Our Ref: BE/135/18/PL
Your Ref:

Town & Country Planning Act 1990 (as amended)
Town and Country Planning (Development Management Procedure) (England) Order 2015
Application for Planning Permission

Development Hybrid application comprising of Outline application for 2 No. distribution warehouses (Units 1 & 3).
Full application for Class B8 warehouse with fuel island & car parking (Unit 2), 2 No. Class B1/B8 employment units with associated parking & servicing (Units 6 & 7), Class A1 retail food store with car parking & servicing (Unit 9), 2 No. drive thru units with car parking & servicing (Units 4 & 5), car showroom, workshops (Including MOT testing), vehicle storage, external display areas, service areas & parking (Unit 8) together with access roads, associated ground & engineering works, landscaping & ancillary works. This application affects the character & appearance of the Shripney Conservation Area & a Public Right of Way.

Location Salt Box Field Land off Rowan Way Bognor Regis

### Ground floor plan

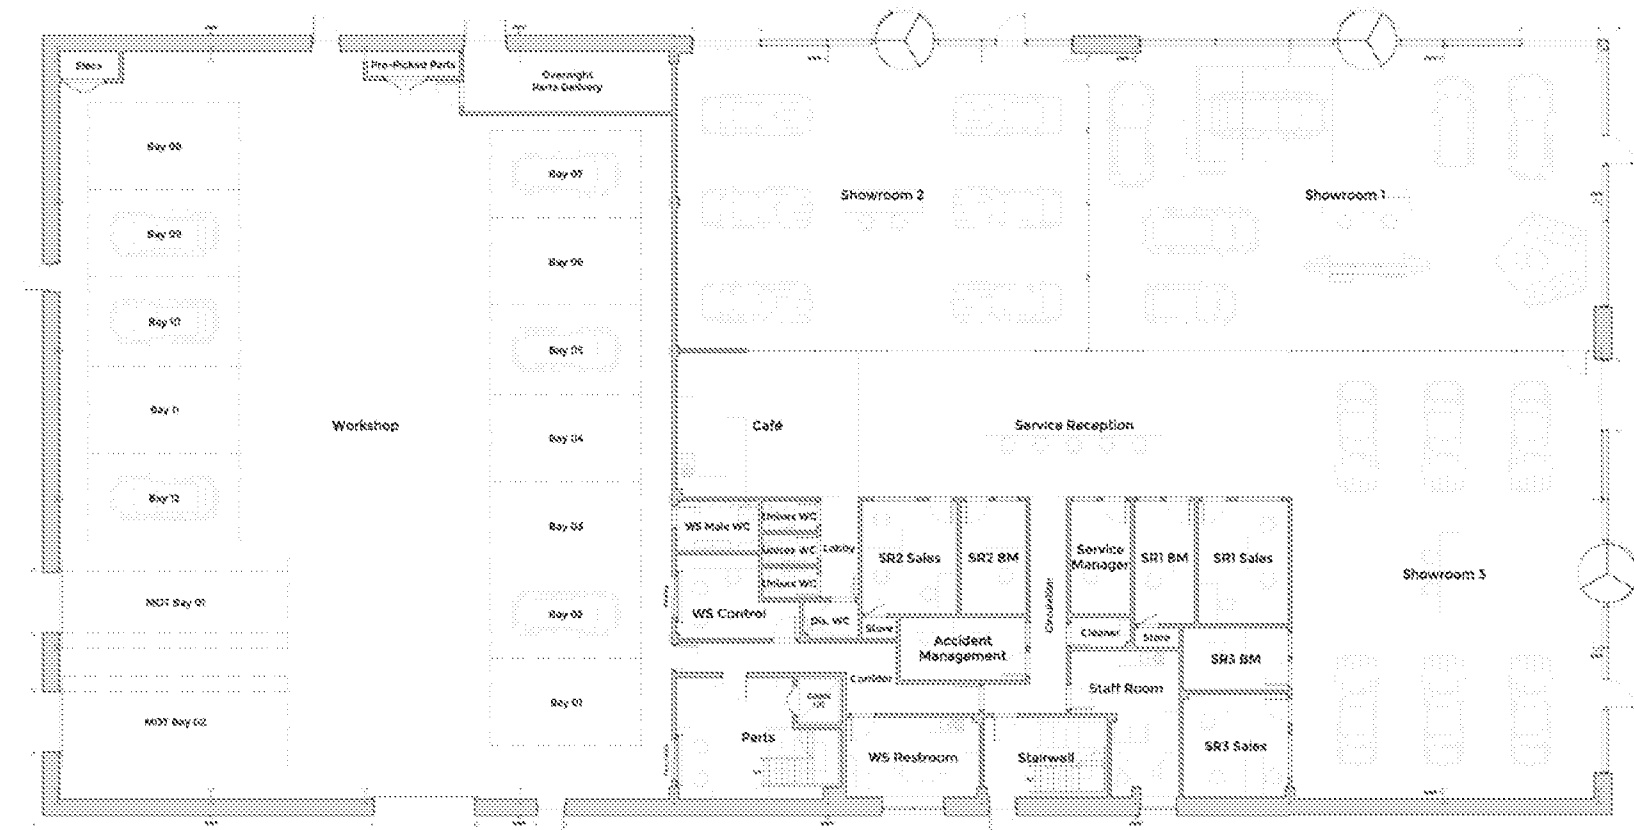
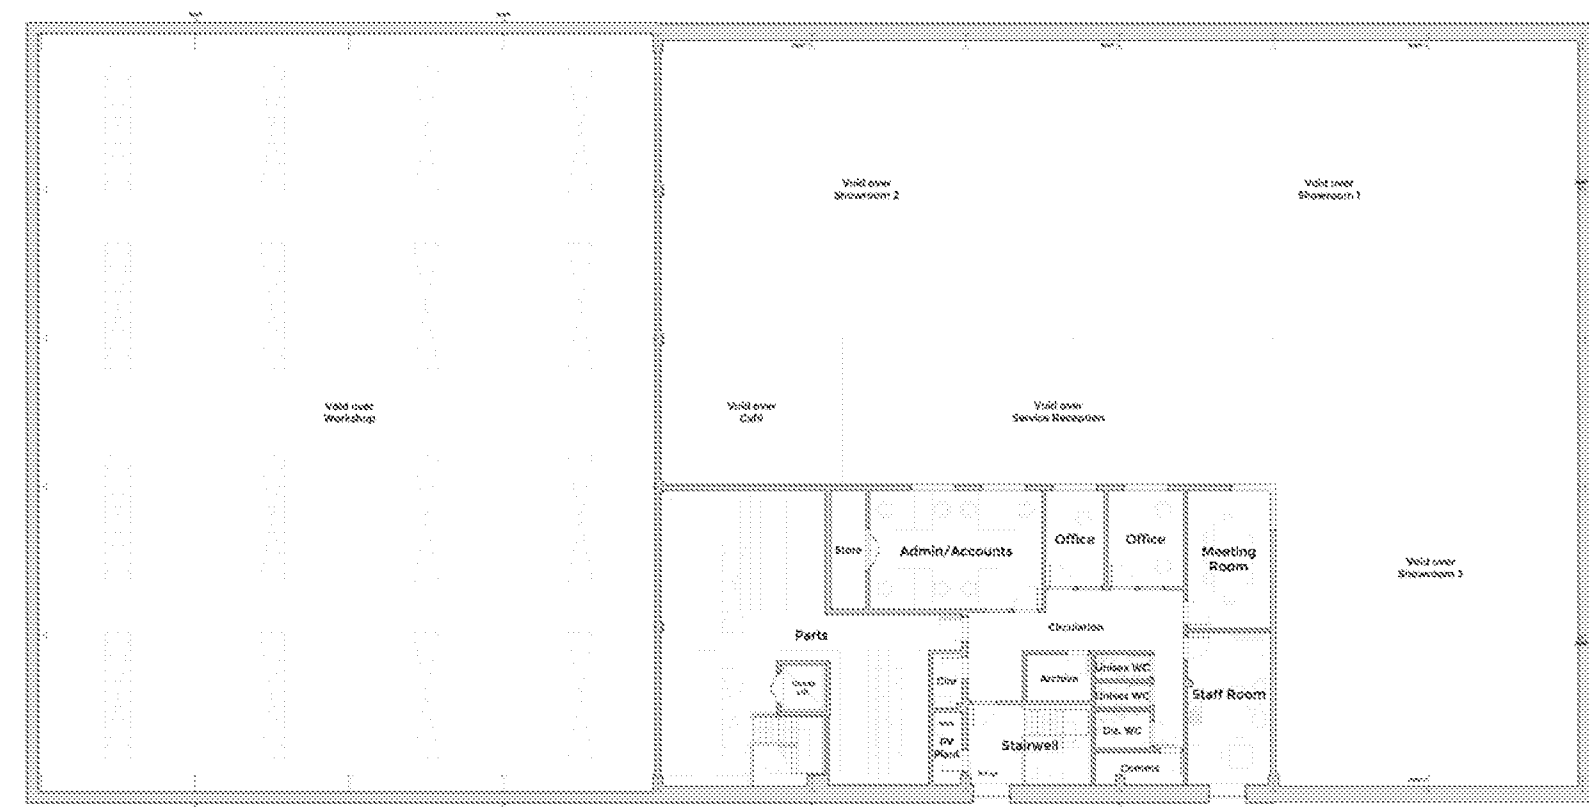
Unit 8's floor plan and elevations do not accord according the north point on the floor plan. Please amend accordingly.
